Recommendation Report for Planning Permission

REF NO: LU/216/20/PL

LOCATION: 2 Wick Parade
Wick Street
Littlehampton
BN17 7JQ

PROPOSAL: Change of use from newsagents (A1 shop) to hot food takeaway (A5 Hot Food Take Away), replacement shopfront including ATM, external alterations to rear elevation & installation of roof mounted extract flue & fresh air intake pipe (re-submission following LU/84/20/PL). This application is in CIL Zone 4 (Zero Rated) as 'other development'.

PROPOSED FLOOR PLAN

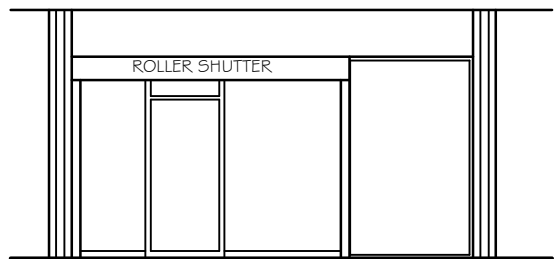
The layout plan shows a toilet opening onto the kitchen/food handling area without an intervening lobby, which does not comply with food hygiene requirements.

However, the proposed site plan or floor plans do not show refuse storage to service the hot food take-away use. As such, in order to ensure appropriate refuse and recycling storage is secured for this use, in accordance with ALP policy WM DM1 and the National Planning Policy for Waste, a planning condition will be added.

The ADC Parking SPD does not require cycle parking provision for A1 uses below 100sqm, which this unit is. However, for A5 uses, the standards do require 1 cycle parking space per 4 staff members and 1 cycle parking space per 25sqm for customers. Given the size of the unit (approx. 88sqm) and the expected number of staff for this type of use (between 1-4), the LPA considers it reasonable to expect the provision of 4 cycle parking spaces. The proposed site plan or floor plans do not show any cycle storage. As such, this is to be secured by condition.

- 8 No part of the development shall be first occupied until details of the refuse & recycling storage and either kerbside collection point for municipal refuse vehicles or a Waste Management Plan agreed with a commercial refuse collection company has been submitted to and approved in writing by the Local Planning Authority. The approved bin storage shall thereafter be retained and any approved Waste Management Plan adhered to.

- 9 No part of the development shall be first occupied until details of covered and secure cycle parking storage (accommodating a minimum of 4 cycle parking spaces) has been submitted to and approved in writing by the Local Planning Authority. The approved cycle parking storage shall thereafter be permanently retained in good working condition.

PROPOSED SHOPFRONT

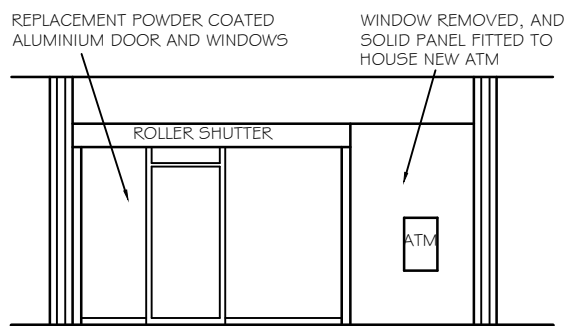
The proposal includes the replacement of the existing shopfront with new powder coated aluminium framed glazing and the replacement of one of the existing glazed panels with a solid wall panel and ATM. The existing shopfront is aluminium framed and there are other aluminium framed shopfronts and a variety of materials and designs for shopfronts within the parade. At the rear, the proposal includes a reduction in the width of the high level ground floor window to accommodate the addition of intake and extract flues at flat roof level above the ground floor. These would be sited at low level on the building, and at the rear of the parade away from public view and thus there would be limited visibility of them. In addition, there are already a range of air con units and flues along the units at the back of this parade. As such, the proposed alterations and additions would have an acceptable visual impact on the appearance of the building, the parade, and local area, in accordance with policies D SP1, D DM1 and D DM4 of the Arun Local Plan.

THE SITE
PROPOSED REAR
ELEVATION

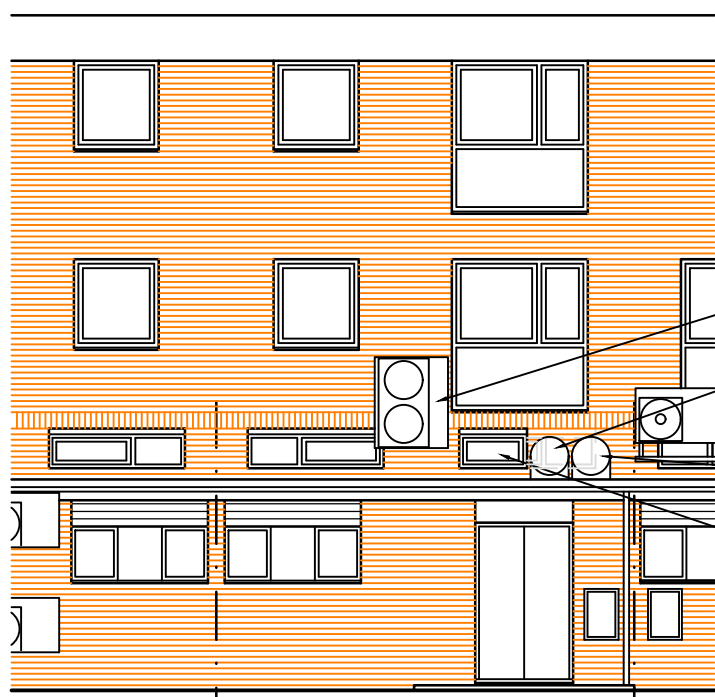
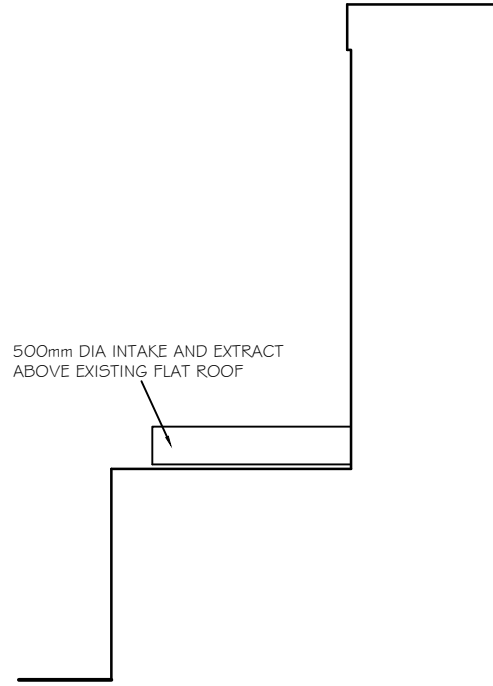
The commercial use is in character with the existing shopping parade. The LPA acknowledges that a hot food take-away use (and the proposed associated plant i.e. air con/flues etc.) could have greater impacts on residential amenity, for example in terms of general disturbance, noise and odours, than the existing retail shop use. The nearest residential properties are the flats at upper floor level directly above the commercial unit and along the shopping parade and the properties at the rear, on Selwyn Avenue. The Council's Environmental Health Officer has provided comments, requesting conditions requiring installation of a grease trap/separator in kitchen drainage/waste disposal, details of extraction and treatment of cooking fumes and odours, plant noise and vibration, a noise report, prohibiting food or drink to be consumed outside the premises, and restrictions on opening and delivery hours. Subject to these conditions, the impact on residential amenity could be controlled, in accordance with the NPPF (para 127), and policies D DM1, QE SP1, QE DM1 and QE DM3 of the Arun Local Plan.

- 4 Prior to the first operation of the premises, a scheme and maintenance schedule for the extraction and treatment of fumes and odours generated from cooking or any other activity undertaken on the premises, shall be submitted to and approved in writing by the Local Planning Authority. Any equipment, plant or process provided or undertaken in pursuance of this condition shall be installed prior to the first operation of the premises and these shall thereafter be operated and retained in compliance with the approved scheme.

- 5 Prior to the first use of the premises, details of any plant (including ventilation, refrigeration and air conditioning) and/or ducting system to be used and the method of control of noise and vibration of this plant shall be submitted to and approved in writing by the Local Planning Authority. The development shall be carried out in accordance with the approved details, retained in perpetuity as agreed and the plant/equipment shall be permanently maintained in good order thereafter.
